DRAINAGE REPORT
For
Sunrise Ranch West Subdivision

September 2001

**Re: Revised Drainage Plan for Sunrise Ranch West
Engineer's stamp 9-7-01 (L8/D14)**

Re: Sunrise Ranch West Drainage Report
Engineer's Stamp dated 7-13-01 (L8/D14)

**Figure 6 Onsite Detention Pond
Outfall Structure**

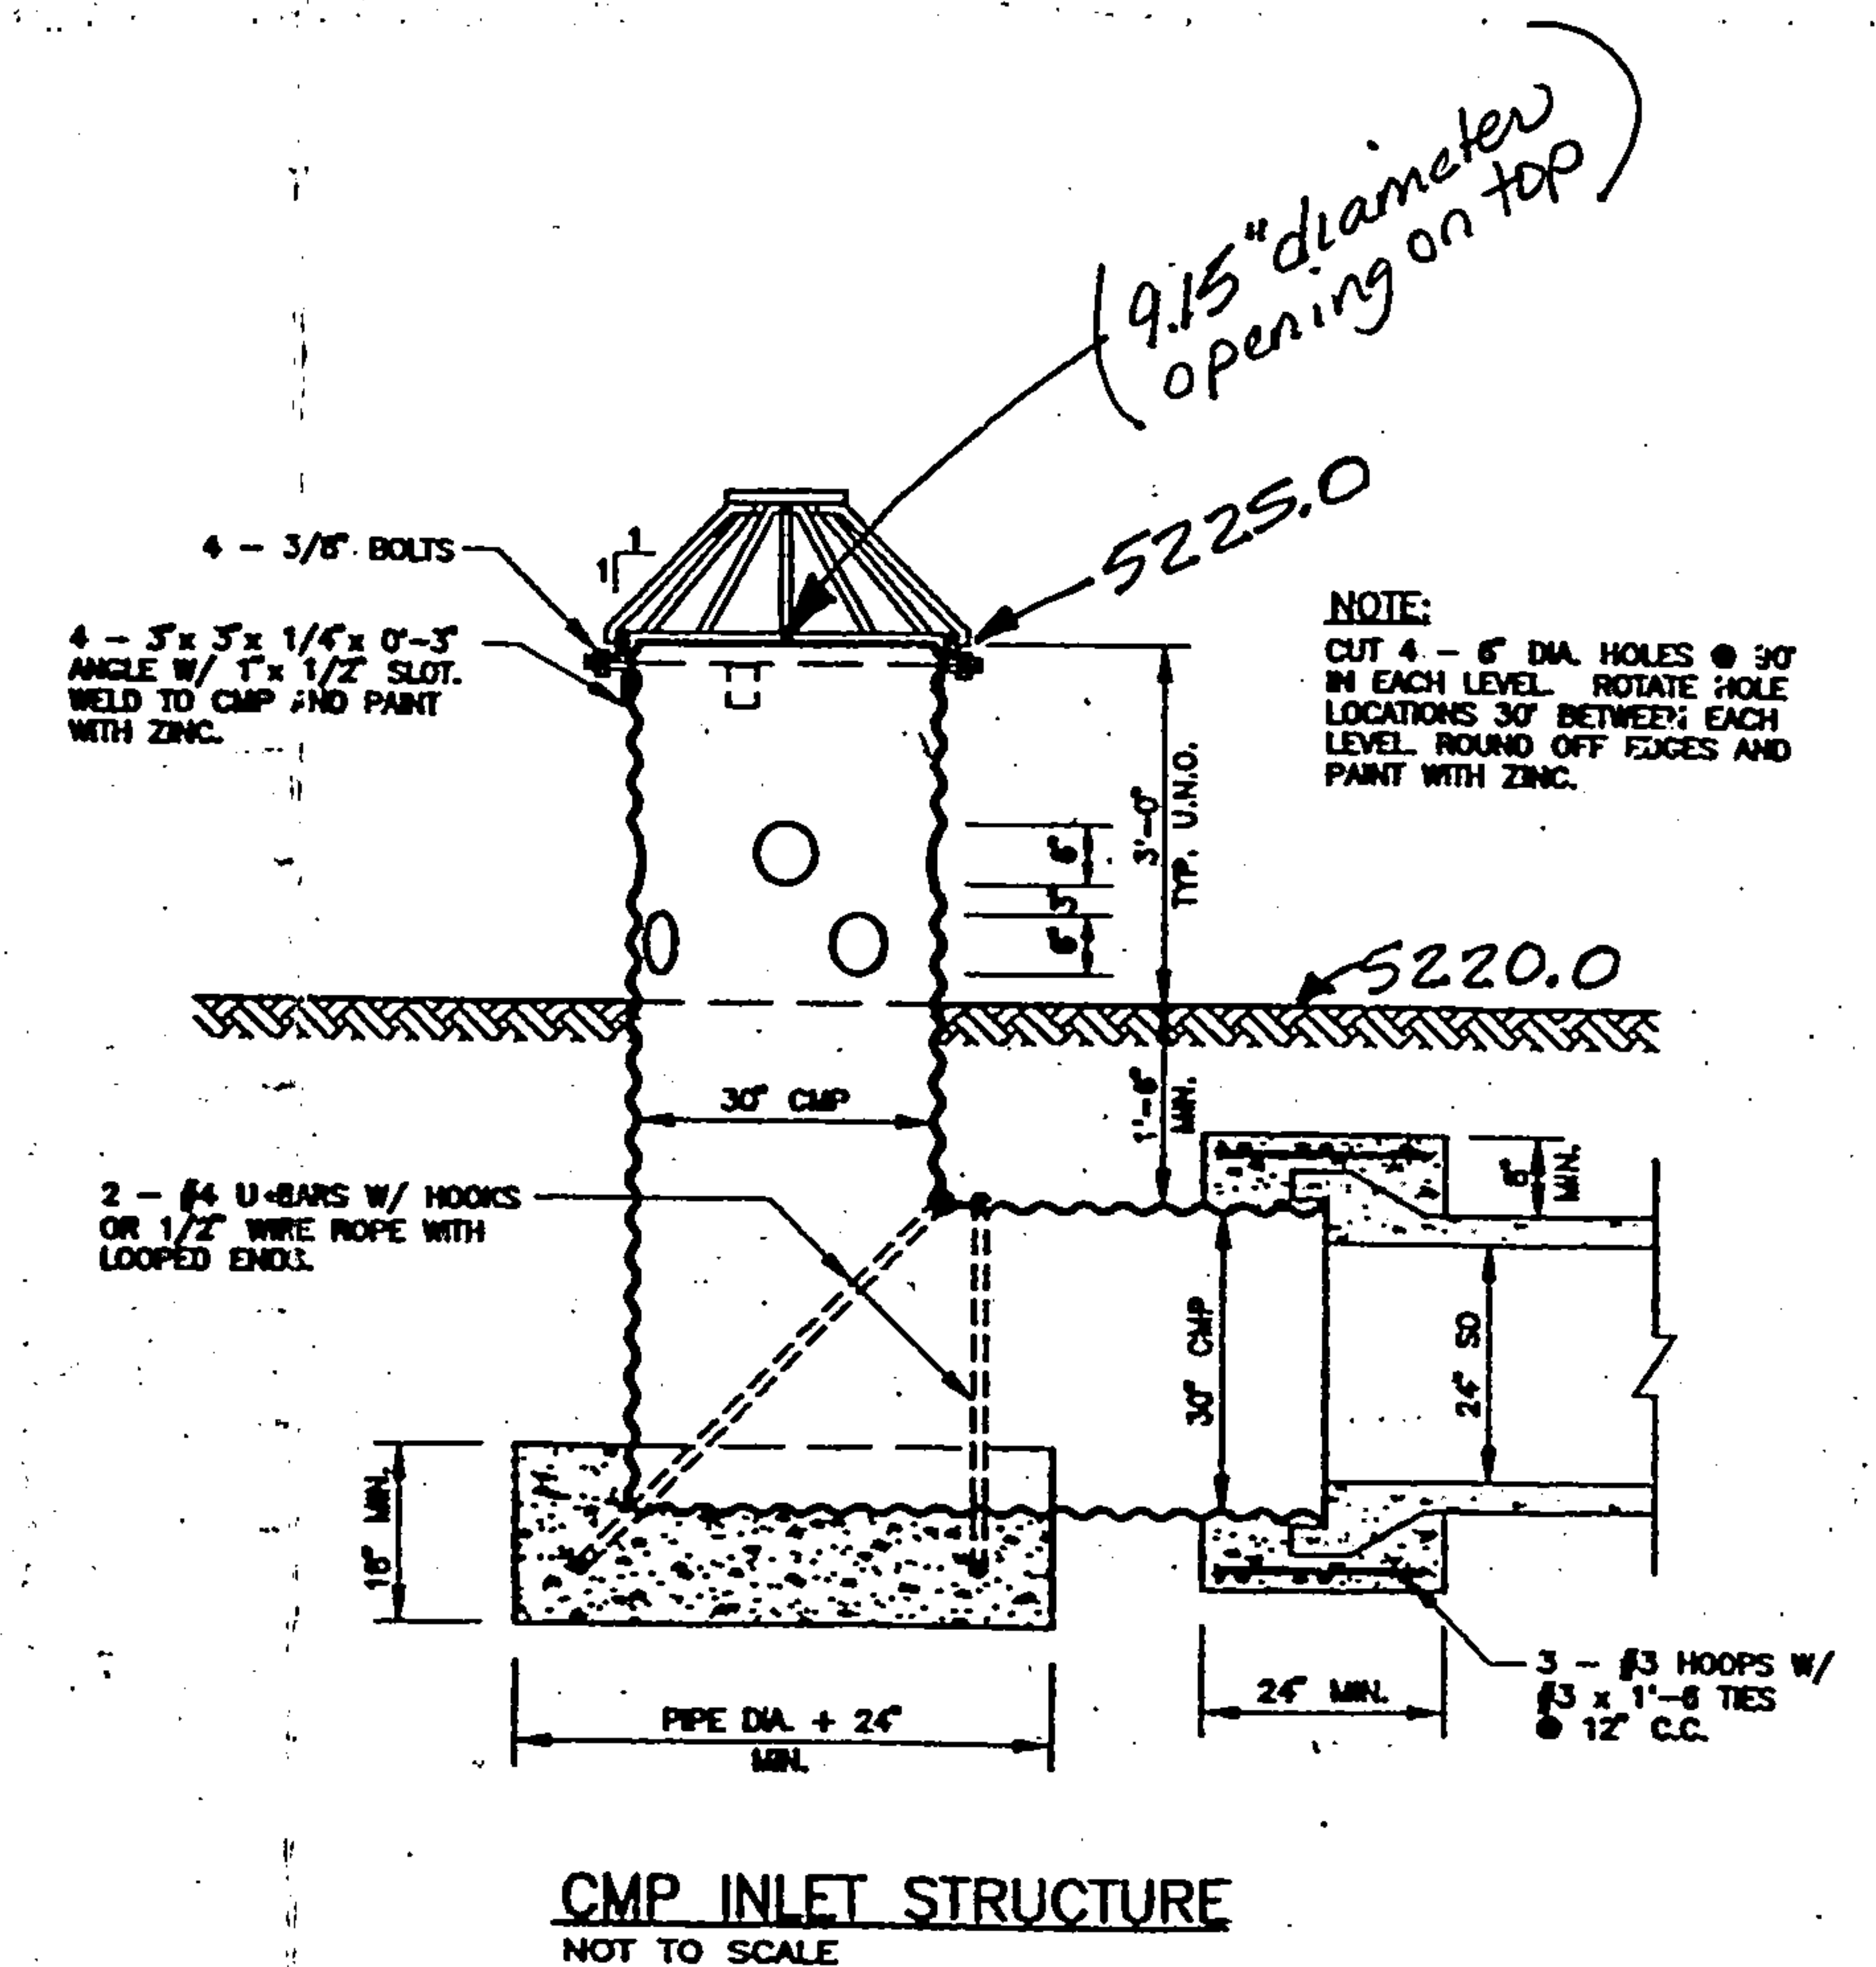
- DISCUSS. • Increasing the size of the ^{correct its intent} outlet pipe from the pond in Basin 160 is not the ultimate condition for this basin. It is wiser to increase the size of the pond than increase the pipe, and then install a smaller pipe upon later development (in order to detain the basin to acceptable levels). *will require increase in reservoir, not possible*

8. Design grades for the backyards of Sunrise Ranch Unit 2 have been added to the G&D plan.
9. To increase the size of the pond would require the limits of the temporary drainage easement to increase. I doubt that the current property owners would agree to this. Since the allowable discharge to the Snow Vista Pond from this existing offsite pond is much greater than the current design discharge from the outfall structure, adjusting the existing outfall structure to allow an increase in discharge is the best solution for the interim condition. When the site west of 106th street develops, the storm sewer can remain and an orifice plate constructed to restrict the "developed conditions" runoff to the allowable discharge.
